From: Chantelle Bashford <Chantelle.Bashford@arun.gov.uk>
Sent: 09 November 2020 13:59
To: Planning.Responses <Planning.Responses@arun.gov.uk>
Subject: RE: Planning Consultation on: BR/244/20/PL

Application No: BR/244/20/PL
Registered: 20th October 2020
Site Address: The Beach Hotel, former Mud Club Waterloo Square Bognor Regis PO21 1SU
Grid Reference: 493500 98875
Description of Works: Redevelopment into 11 No. 2 bed apartments & 2 No. commercial units (A1 Retail or A3 Restaurant/Cafe) (resubmission following BR/282/19/PL). This application affects the character & appearance of The Steyne, Bognor Regis Conservation Area & may affect the setting of listed buildings. This site is in CIL Zone 4 (Zero Rated) as flats & other development.

Document Title:
Proposed First Floor Plan

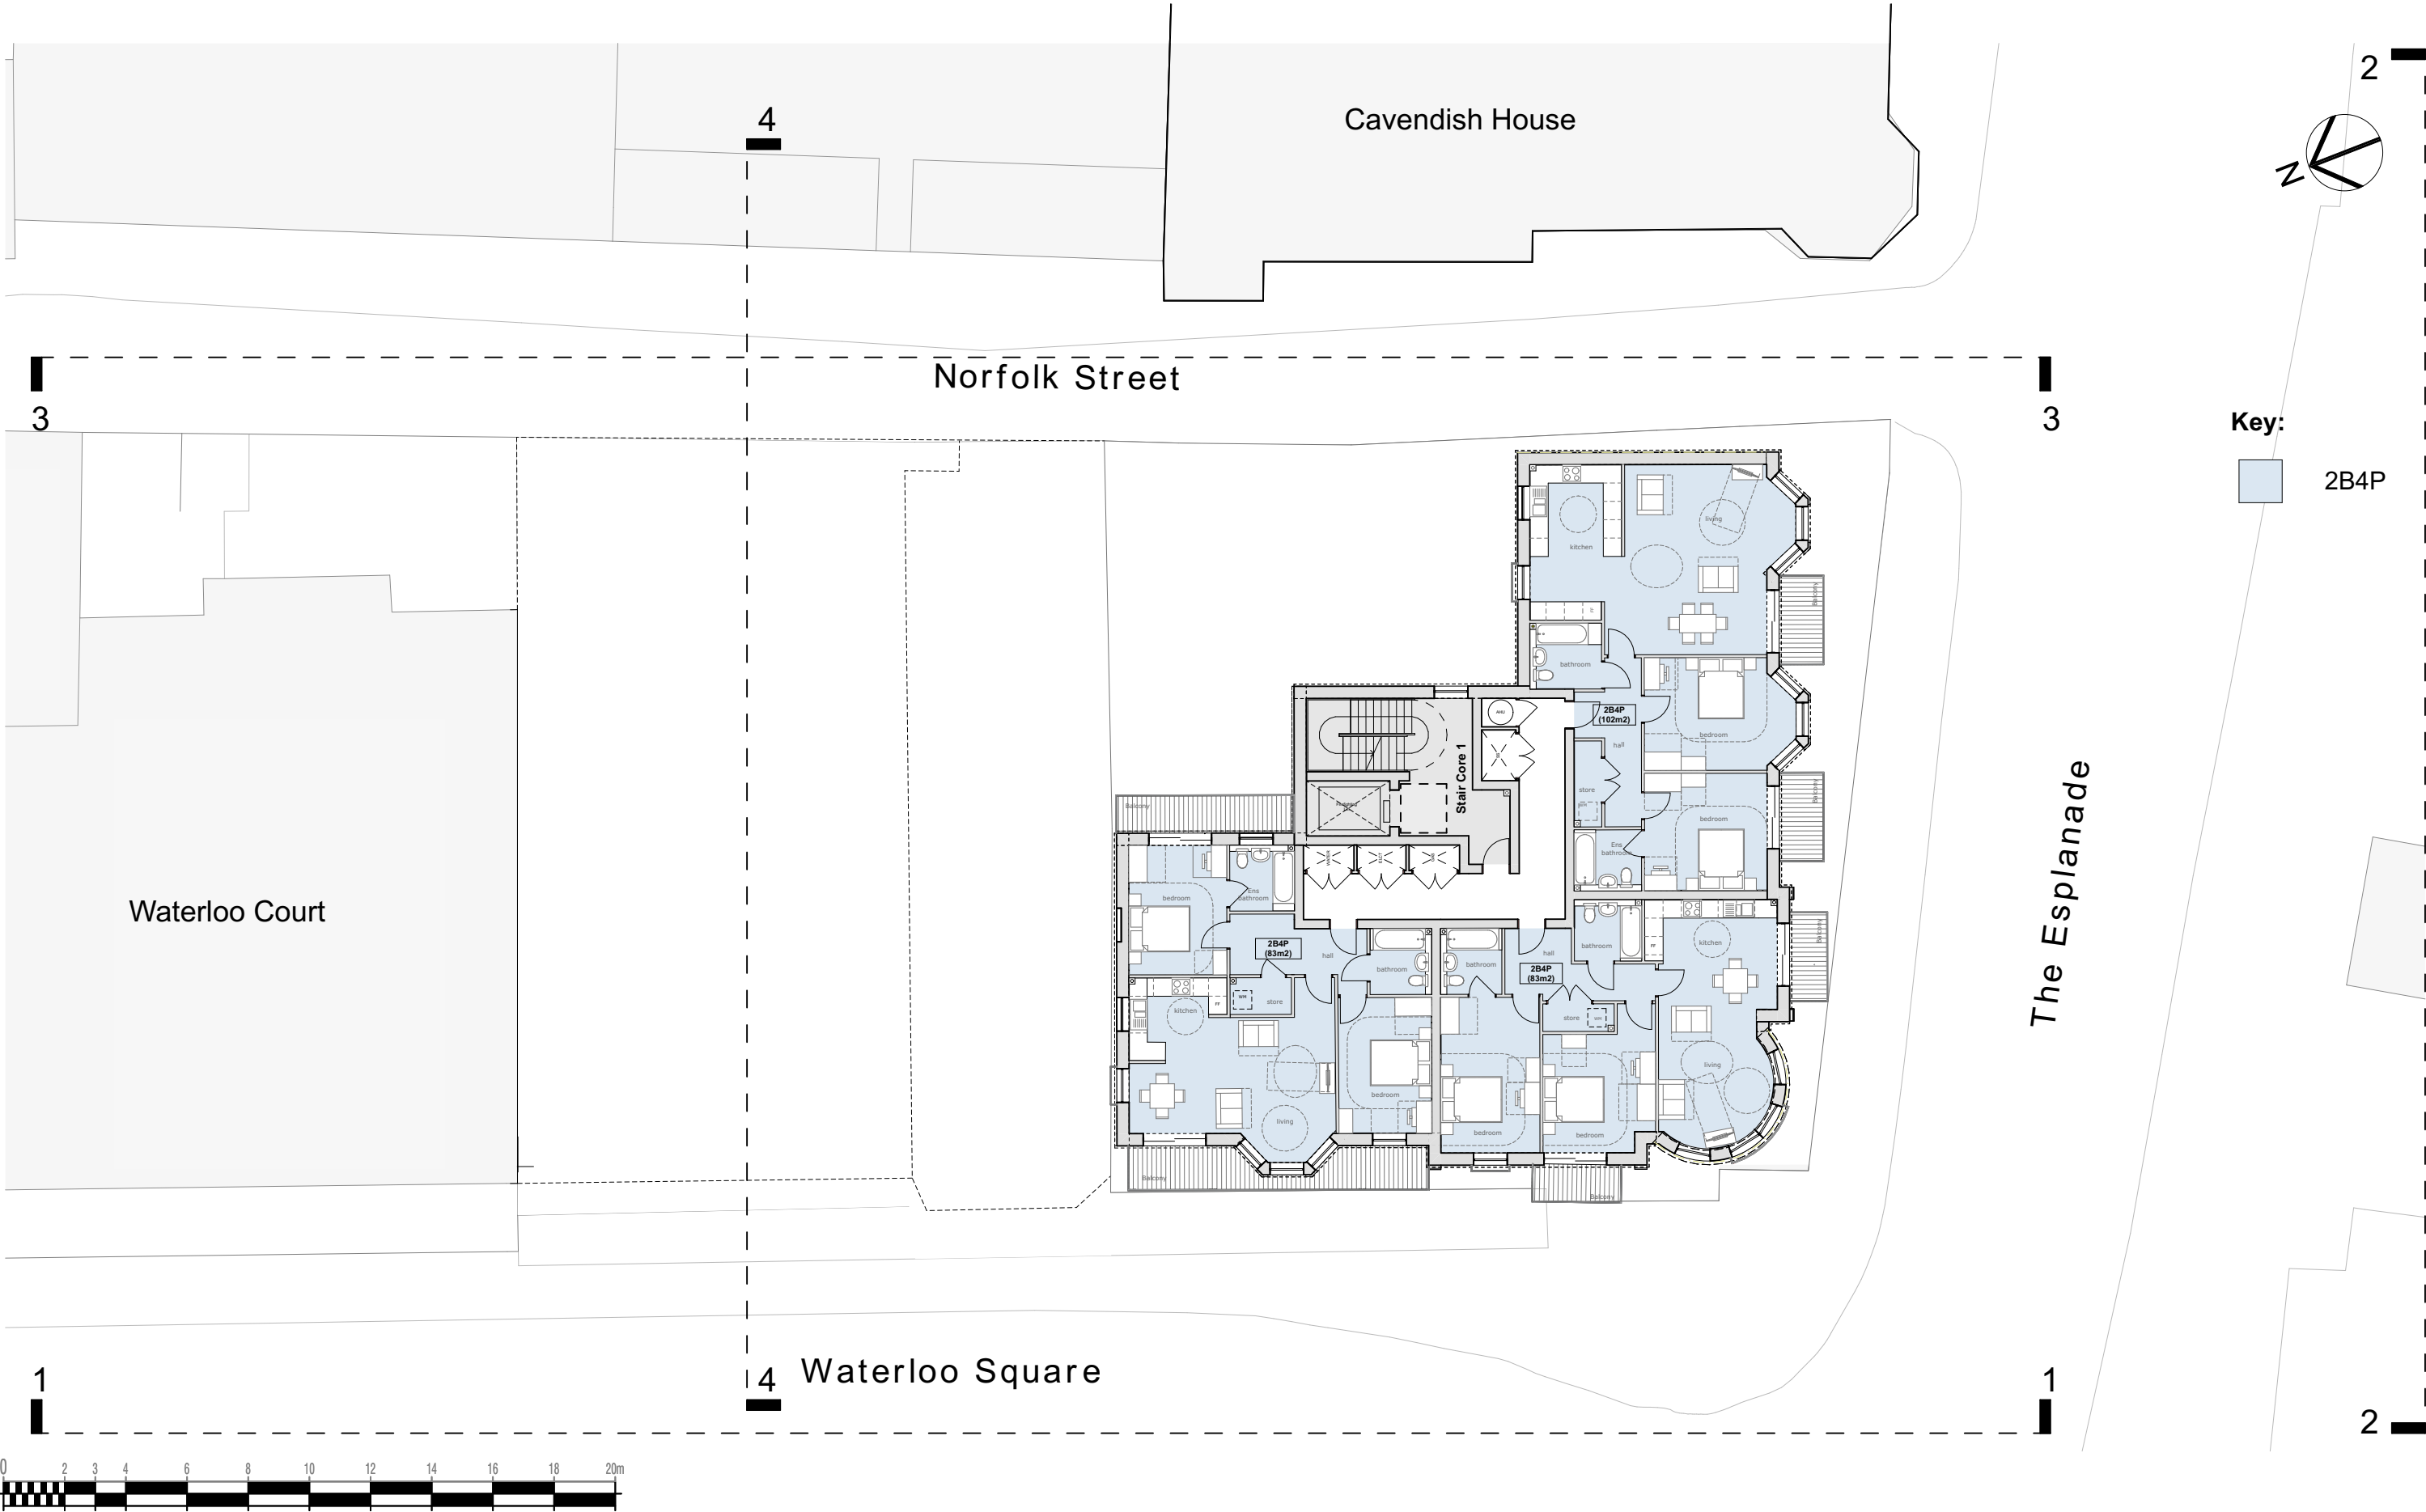
- Non-interlinked mains-wired smoke alarms with integral tamper-proof battery back-up to each flat
- Fire blankets should be provided to all kitchen areas
- Emergency lighting required to the escape route due to the travel distance
- A number of the flats have the kitchen areas backing onto a bedroom. The compartmentation between these rooms must afford 30 minutes fire resistance. These rooms are:
 - First floor south/east flat bedroom backing onto first floor south/west flat kitchen (this is the same for the second, third and fourth floors)
 - First floor north flat rear bedroom backing onto the kitchen (this is the same for the second and third floors)
